# Proposed SHD – Lands at Central Mental Hospital, Dundrum, Dublin 14

**Stage 1 Quality Audit**

1	AUDIT INFORMATION	
1.1	Title	CMH DUNDRUM QUALITY AUDIT
1.2	Audit Reference Number	CMH DUNDRUM QUALITY AUDIT MA 326
1.3	Project Code	CMHDUNDRUM
1.4	Date Audit Completed	21 <sup>st</sup> January 2022
1.5	Audit Attended By	Ludmila Santos
		Mark Andrews
1.6	Audit Team	
	Team Leader	Mark Andrews, ILTP
	Team Member	Ludmila Santos, ILTP

**Figure 22 - Site plan highlighting vehicle (dark blue) and on-site bicycle (light blue) parking. Each apartment block has both vehicle and bicycle parking facilities.**

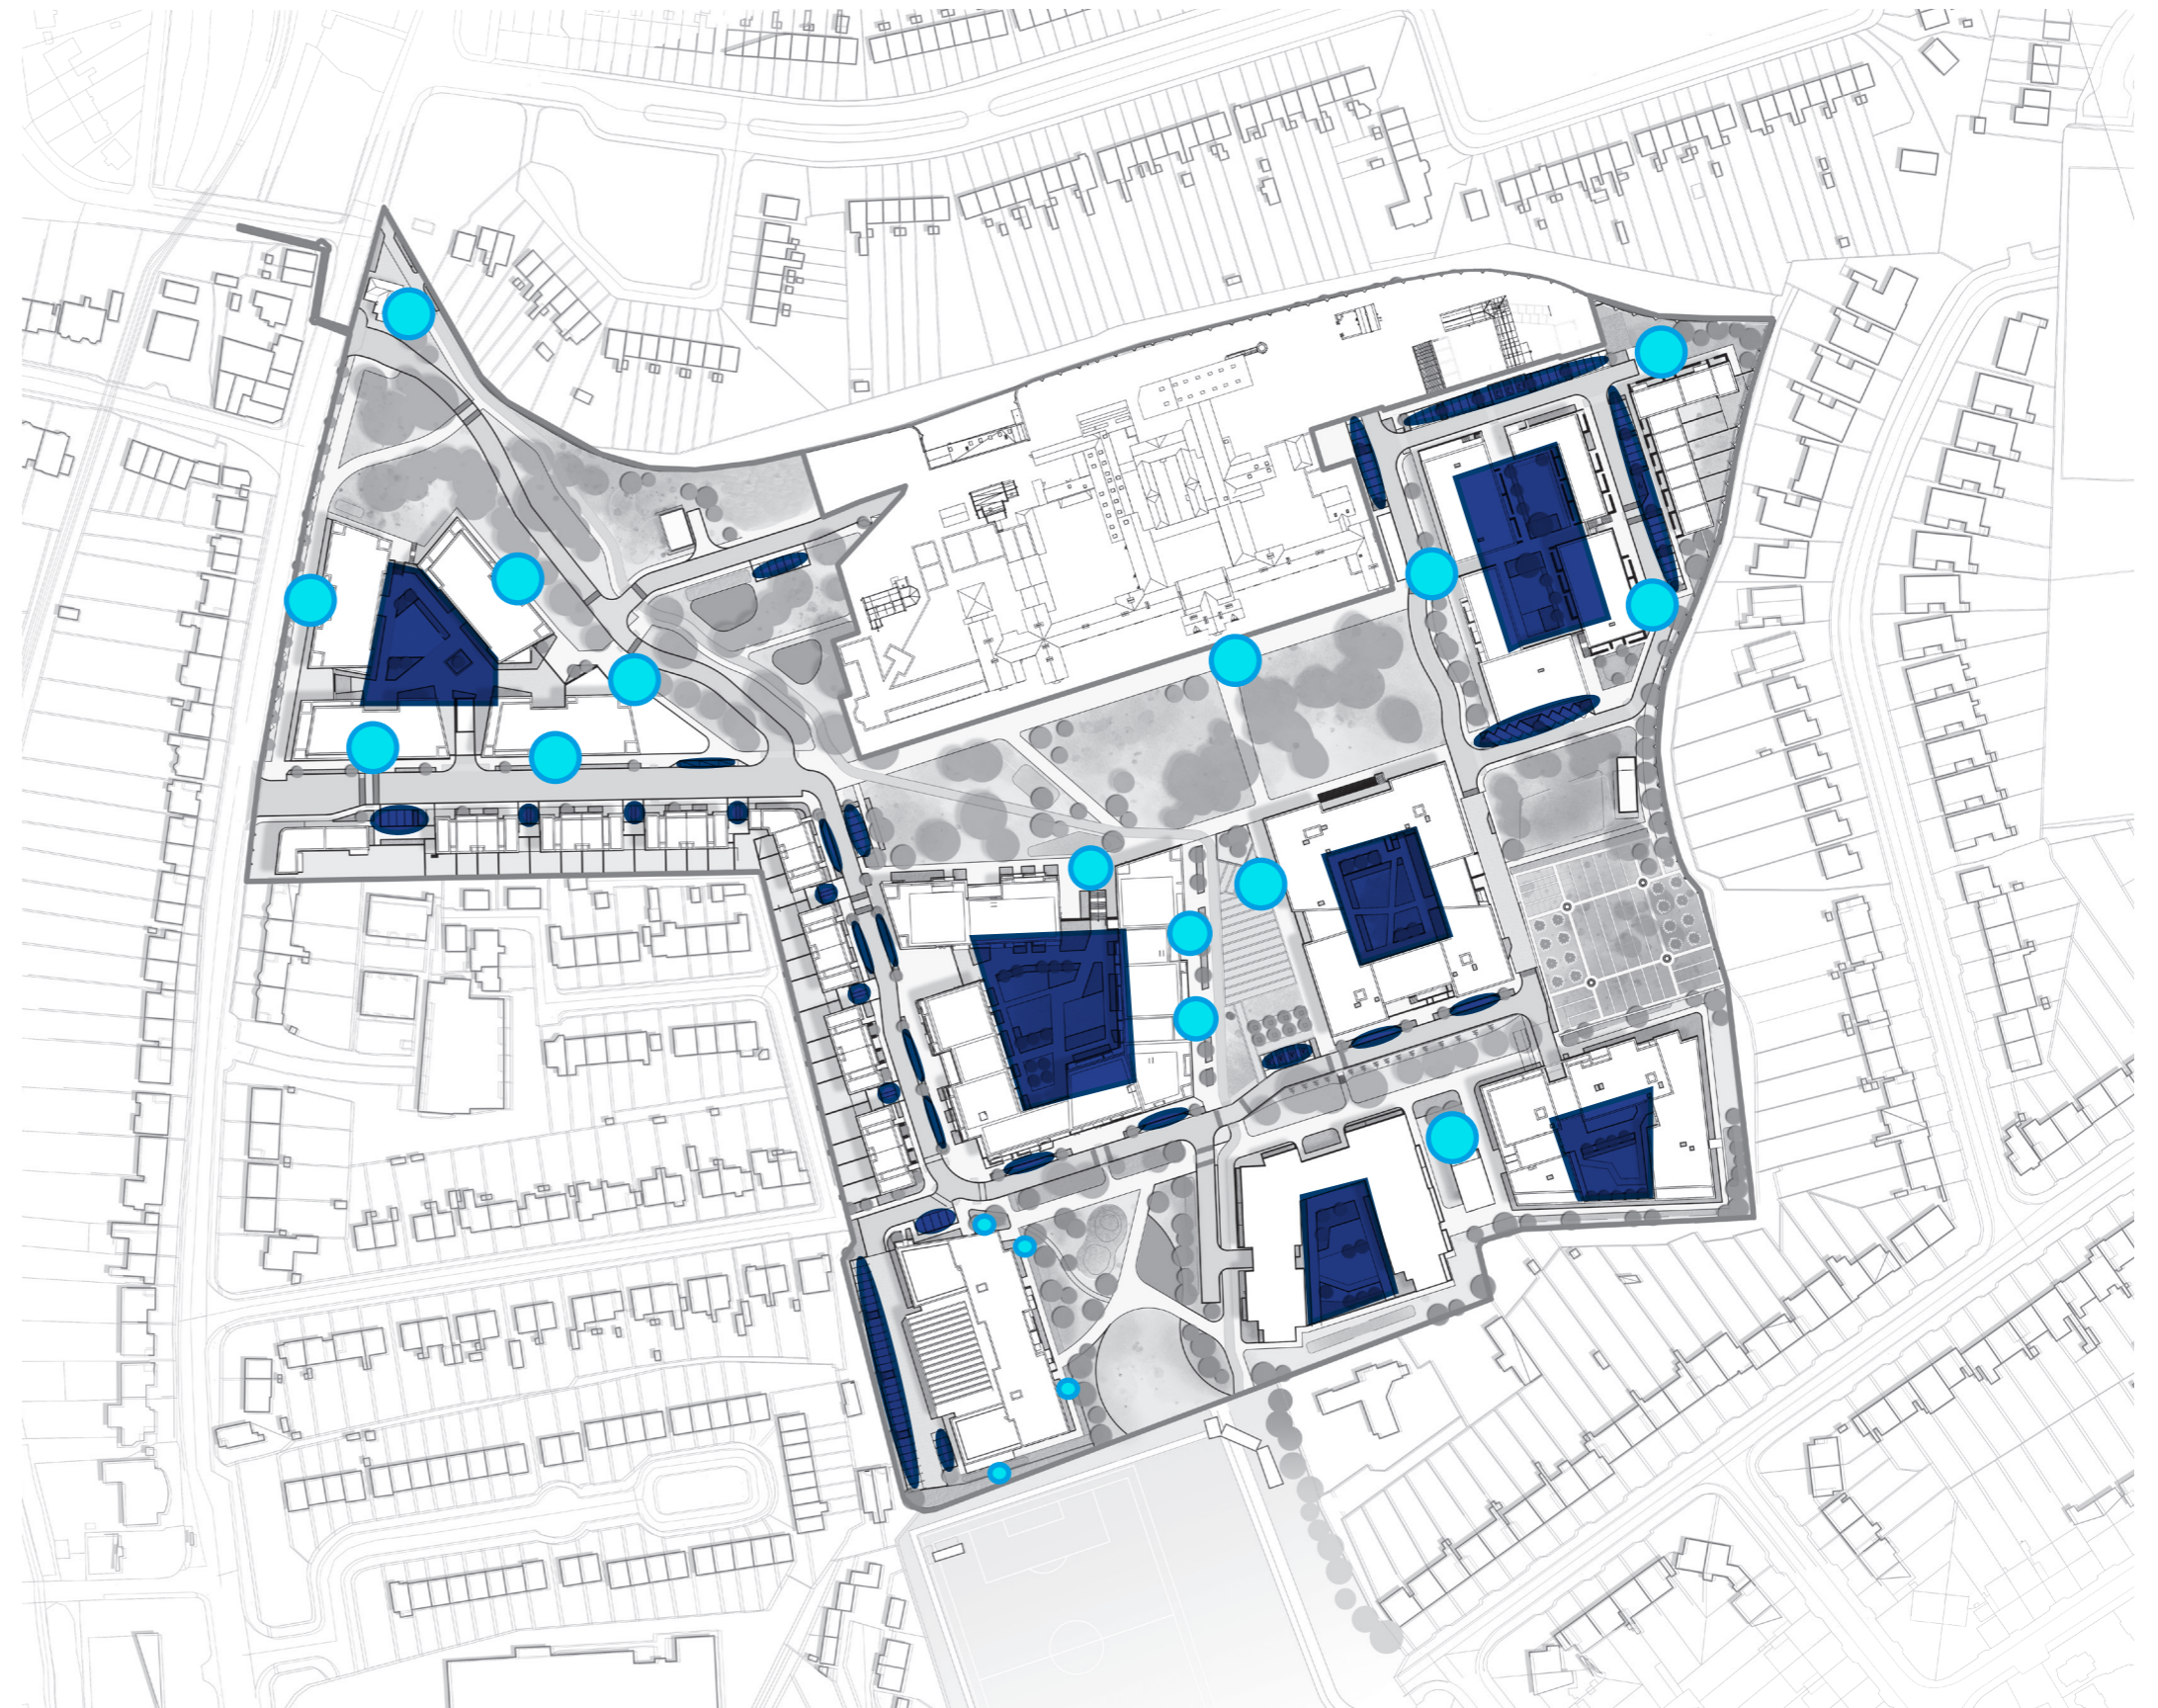
The drawings provided for audit do not include details of cycle parking areas or provisions.

The information shows cycle facilities throughout the site with crossing points. However, there are no details of cycle parking which is assumed to internal to the accommodation blocks. The design team should ensure that appropriate facilities are provided for both residents and visitors to store cycles in order to promote the use of sustainable transport modes.

The design team must ensure that appropriate facilities are provided and indicated on the drawings as to the type and location to be provided.

Para No. in Report	Recommendation Accepted (Y/N)	Comments / Alternative Measures (Describe)	Alternative Measures Accepted by Auditor? (Y/N)
4.1.2	Υ	Appropriate cycle parking facilities will be provided for both residents and visitors throughout the development.	Y
4.1.3	Υ	EV car charging spaces will be provided throughout the development at appropriate locations in accordance with DLRCC requirements.	Y
4.1.4	Υ	Appropriate street lighting will be provided within the development.	Y
